Project name:
West Burton C (Gas Fired Generating Station)

Project ref: EN010088

Memo

Subject: Canal and River Trust (CRT) outstanding matters

PROJECT	WEST BURTON C
TITLE	OUTLINE STORM WATER DRAINAGE ARRANGEMENT
SCALE	1:200
DATE	11/01/2012
DESIGNED BY	SW
CHECKED BY	CMW
DATE	November 17
PROJECT NO.	70026636-REP-0006-D4
REV	P01

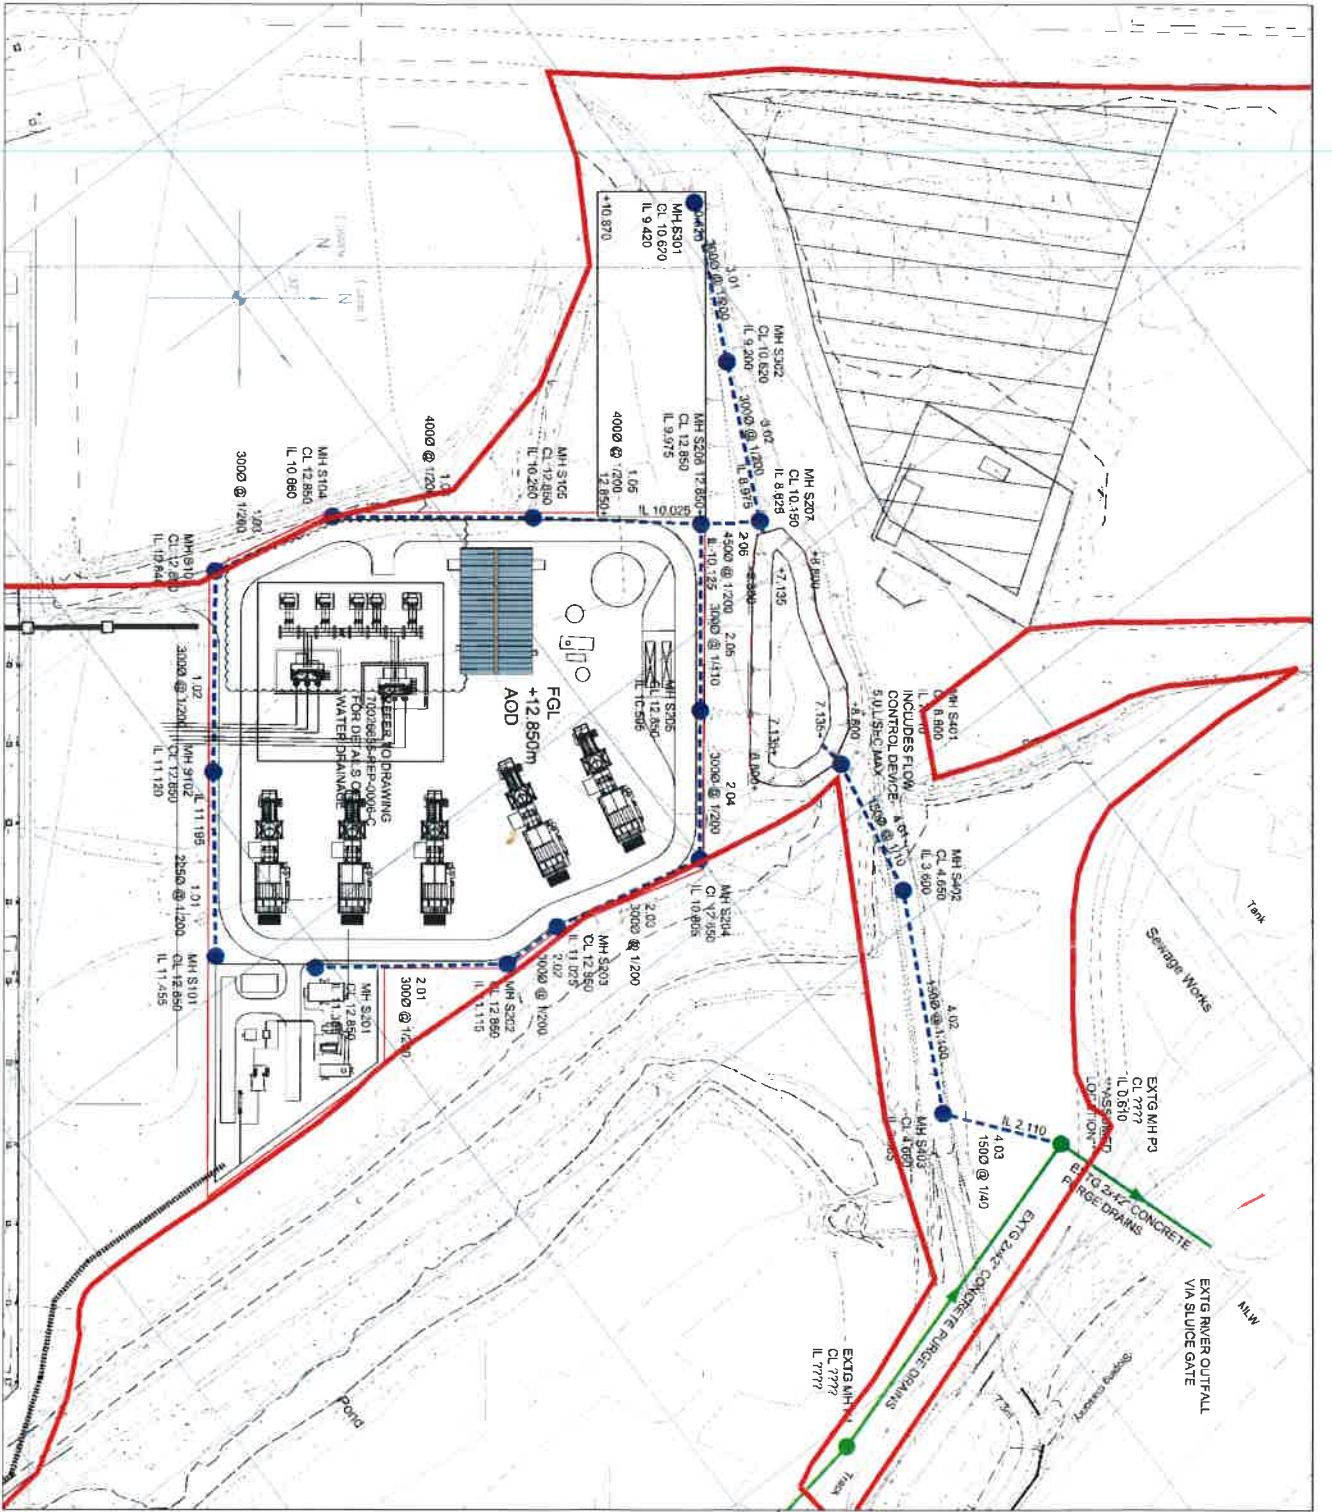
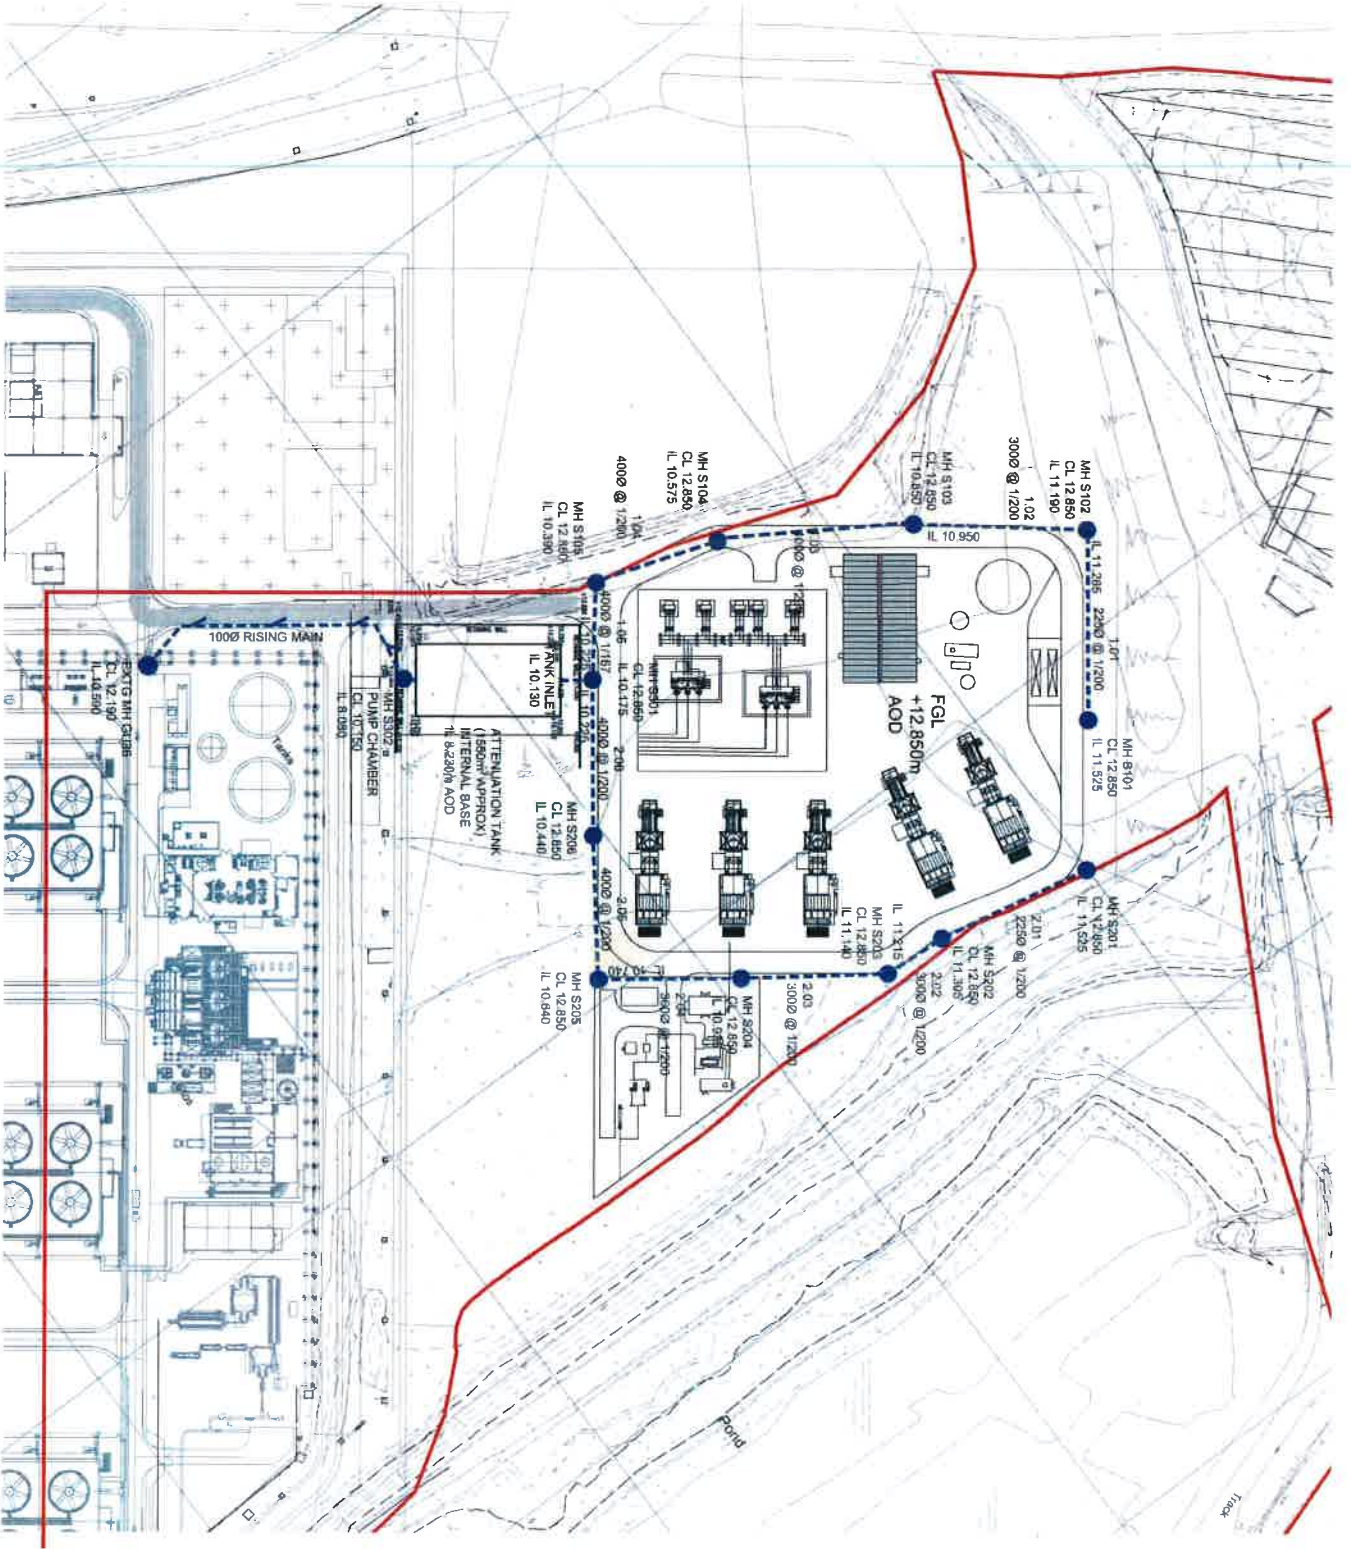
It is understood that the specific scheme has yet to be finalised, and that the overall risk to the waterway is likely to depend upon the final design and option undertaken for the construction of surface water drainage.

The Outline Method Statement highlights that works would comprise of the formation of temporary access roads and excavation works. Three different options have been put forward for these works, with categories A, B and C.

- Should Option B be pursued, the works would be approximately 50m from the river bank (as calculated using the scales provided from the drawings).
- In the absence of full details of the specifications of Option A, these works could be within approximately 30m of the river (i.e. any location within the Works Plan 5 shaded area).

Options A and B would also result in connections to the existing purge drain and outfall to the river, which could have implications for the water flow and velocity, even within the existing discharge licence.

- It is usual for the detailed design for a power station like West Burton C not to be finalised at the planning stage; detailed design only progresses once a project is certain to go ahead.
- Connection options A and B shown are similar and although strategy document (APP-142) only provides detail for option B it can be confirmed that the arrangement is also representative of option A.
- For options A and B the pipe line will be run from a collection pond on the main development site underground and be introduced into the existing purge line via a bored hole through the wall of an inspection chamber, the drain line will be sealed and grouted in

place. It is envisaged that the drain works will be open cut trench work performed by a JCB or equivalent (there will be no requirement for piling).

- Option A, as shown on the drawing, is just over 45m from the river and not 30m.
- Temporary access roads, if required, and excavation works, associated with Options A and B, would be located to the West of the drainage connection and therefore will be further away from the river than the Purge Line. Temporary roads will be minimised and are only required to provide access for a JCB or equivalent and other light weight construction vehicles for the duration of these works.

- The existing purge line consists of 2 x 42” concrete pipelines lines installed when West Burton A was built; water from the purging and draining down of the WBA cooling tower ponds is discharged through the purge line to the River Trent. When West Burton B was built, the purge line was additionally used for the discharge of cooling water and surface water drainage from the WBB.

- The additional rain water flow proposed to be directed through the purge line from the Proposed Development will be small (via a 6” diameter pipe) and the total flow including this additional water will remain within the allowed discharge consent limits specified in the Environmental Permit for West Burton B (WBB). There is no specific limit for surface water discharge in the permit as the rain water would anyway have found its way naturally to the river.

- Option C also discharges water through the purge line although the physical connection is into the WBB surface water drainage pipeline.
- The additional flow of water arising from WBC will therefore be insignificant and will not affect the current conditions in the river.
